OUT21/18596

**Cockle Bay Wharf mixed use development (SSD-9978934)
EIS**

Detailed advice to DPE Planning & Assessment regarding the Cockle Bay Wharf Mixed Use Development (SSD-9978934) EIS

drawing
GA - Podium - Level 00 - Below Ground

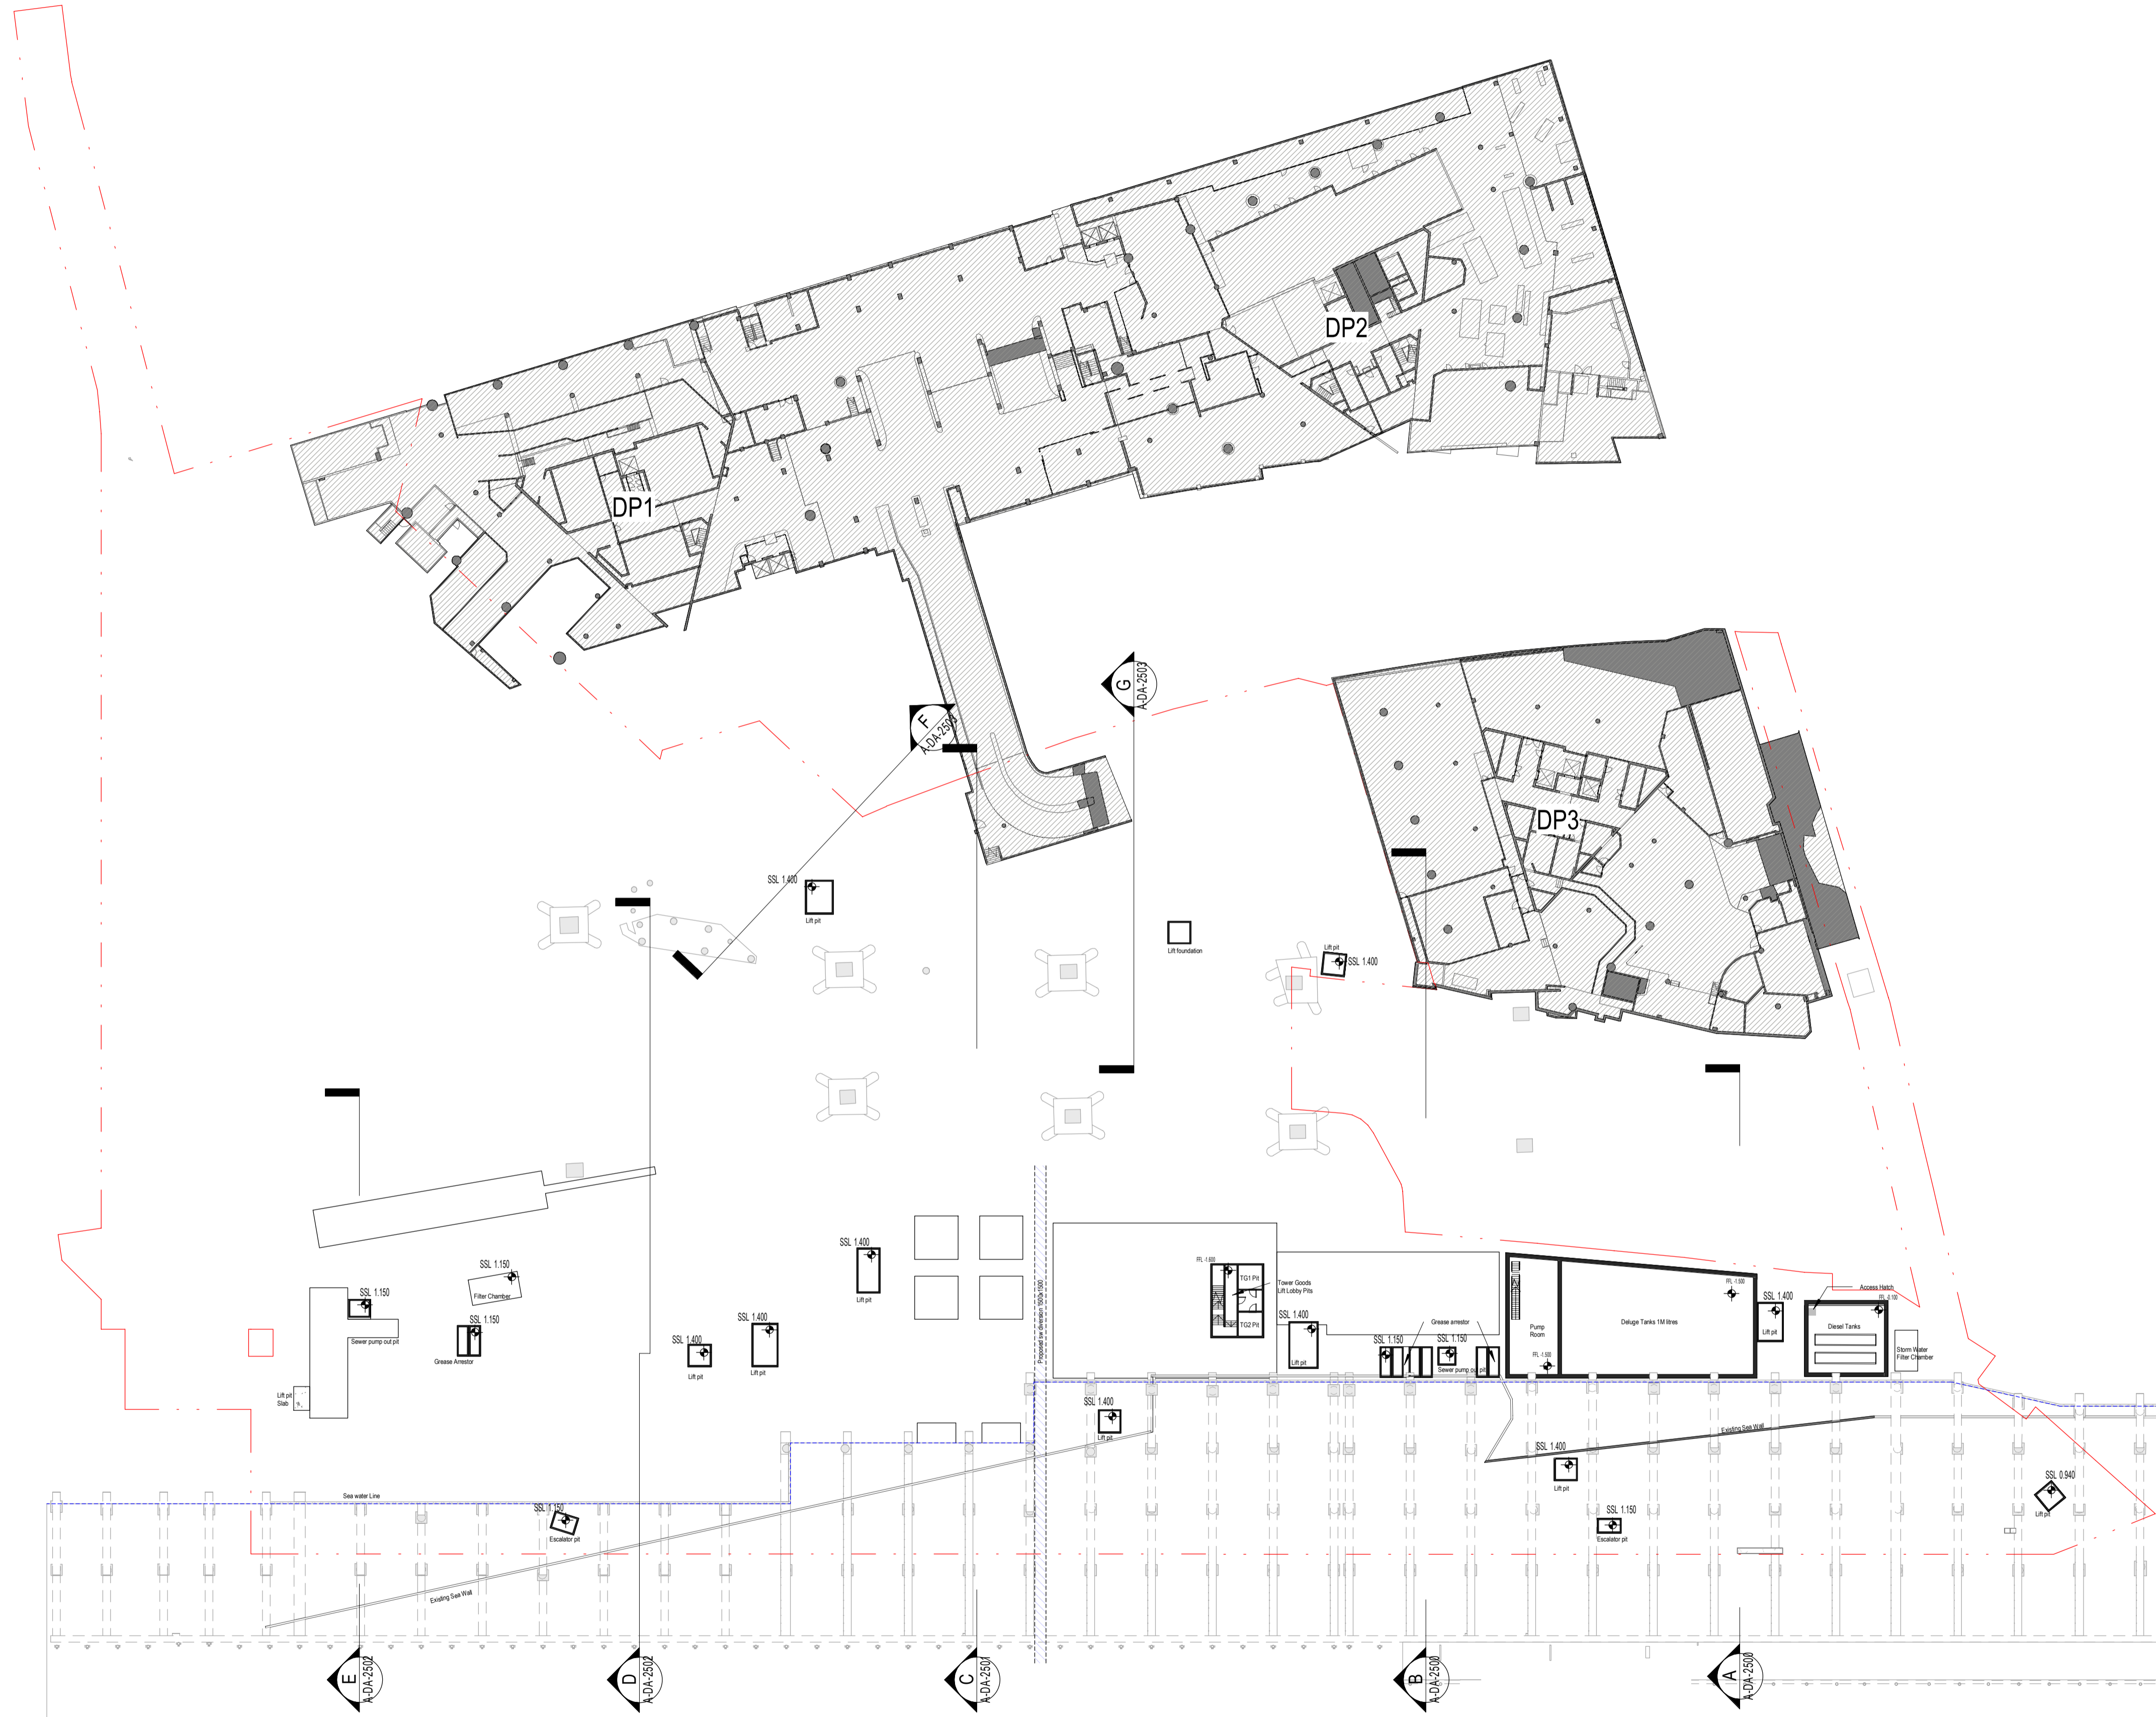
The Stage 2 EIS identifies a high-likelihood of interception of groundwater during construction, including the need to prepare a Dewatering Plan and an Acid Sulfate Soils Management Plan. Page 18 of the Geotechnical Investigation states groundwater is expected to be intercepted during the construction of the fire water tank and basement due to the high groundwater table.

Basements with inverts below groundwater level are proposed. The department asserts that basements which intersect, or are likely to intersect, the groundwater table should be watertight (fully tanked).

- incorporate tanked-basement designs where basements are likely to intersect groundwater.
- prepare a Dewatering Management Plan consistent with the requirements set out in the NSW Government guideline ‘Minimum requirements for building site groundwater investigations and reporting’ (DPIE 2021), in consultation with DPIE Water.
- obtain Water Access Licences in the relevant groundwater source and ensure the proponent has sufficient water available in their account before take commences (unless an exemption applies). The proponent should confirm with NRAR the licencing arrangements for potential groundwater take during construction and operational phases of project.
- prepare and implement an Acid Sulfate Soils Management Plan.
